Our Ref: R/208/20/NMA

**Section 96A of the Town & Country Planning Act 1990 (as amended)
Town and Country Planning (Development Management Procedure) (England) Order 2015 (as amended) - Article 10**

Non material amendment following grant of R/62/20/HH for the variation of materials to garage.
Smugglers 4 Botany Close Rustington BN16 2BH

Plans, Elevations, Roof Plan and Block Plan
Garage -
Proposed

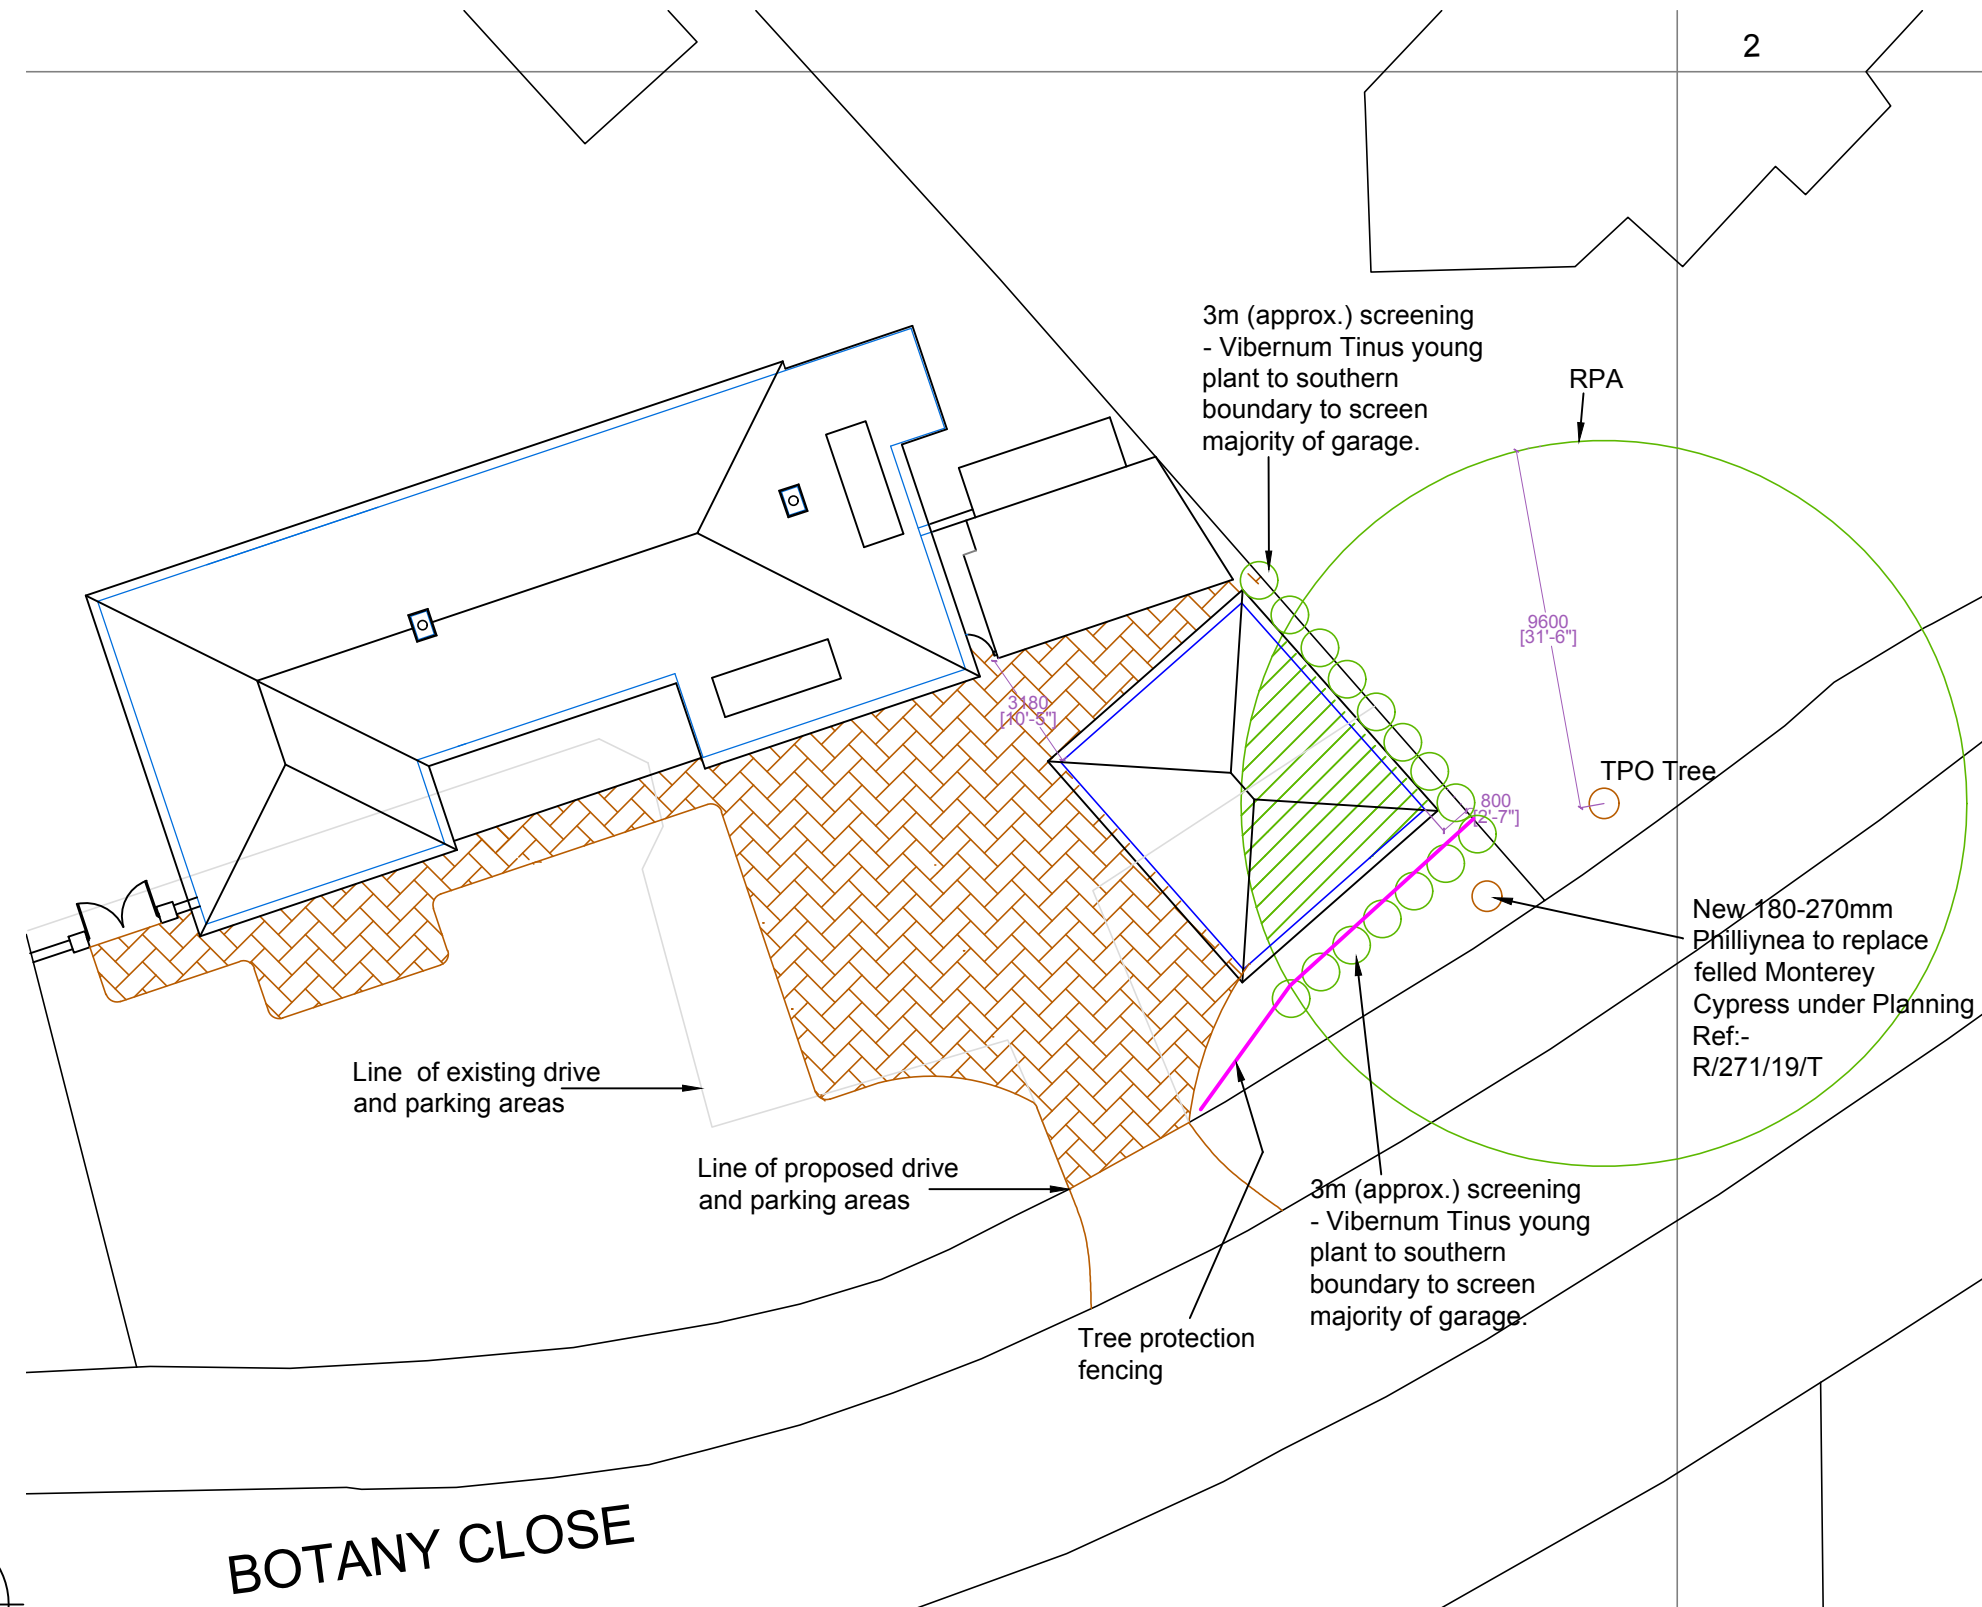
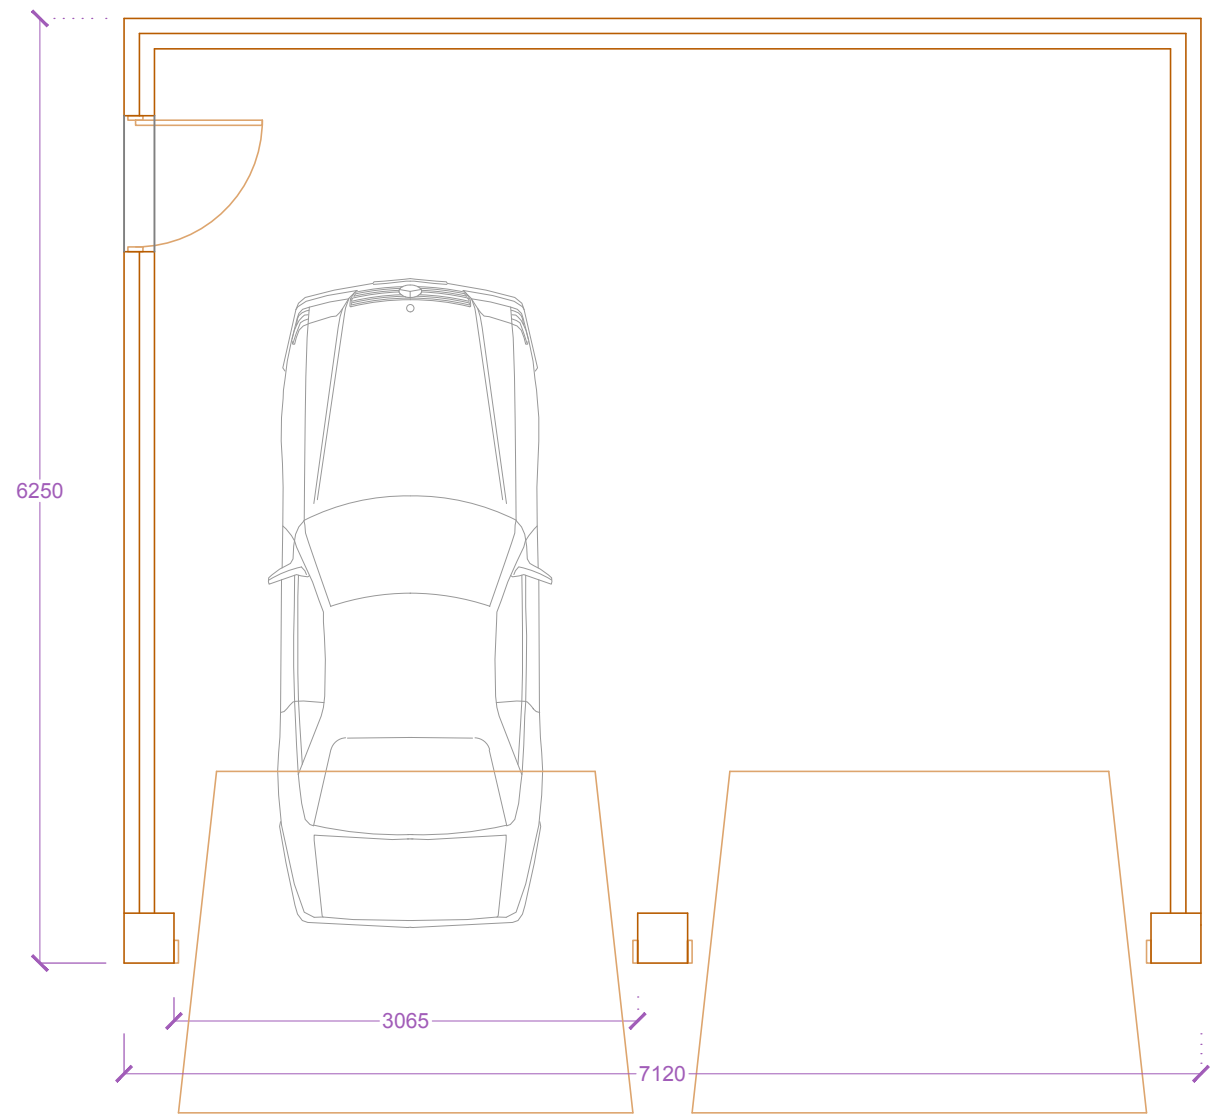
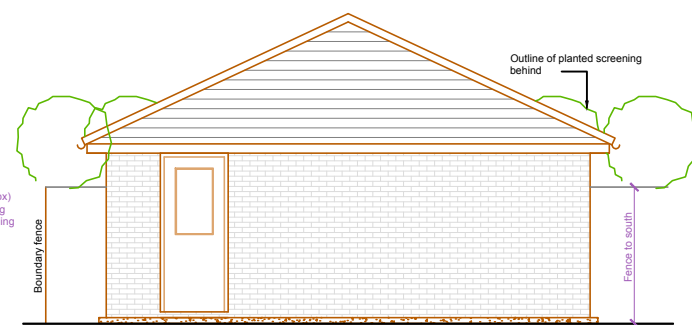
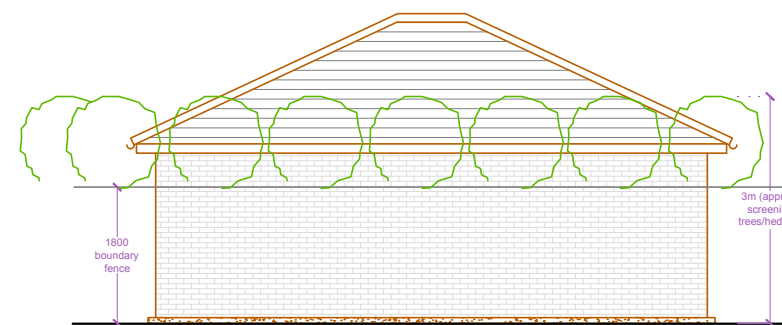
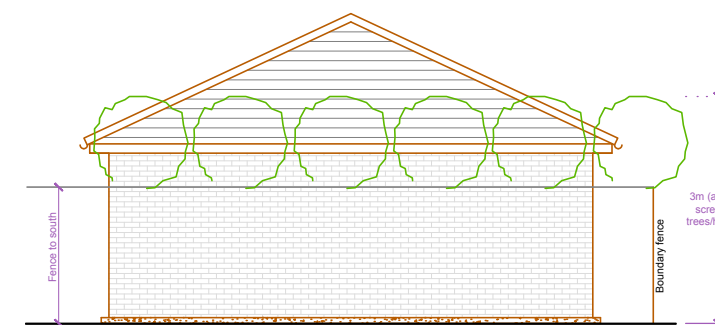
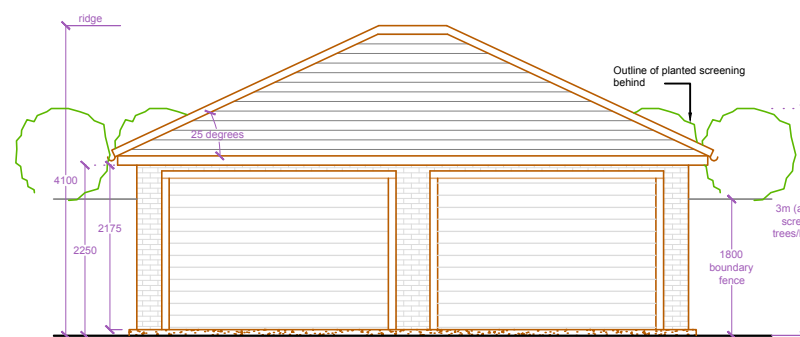
I refer to your recent application for a Non Material Minor Amendment. I note that you seek to alter the proposed materials.

Please note that plan reference 'Plans, Elevations, Roof Plan and Block Plan - Garage - Proposed - 183038/07 - Rev. A - 22/06/20' is now replaced by 'Plans, Elevations, Roof Plan and Block Plan - Garage - Proposed - 193043/07 - Rev. C'.
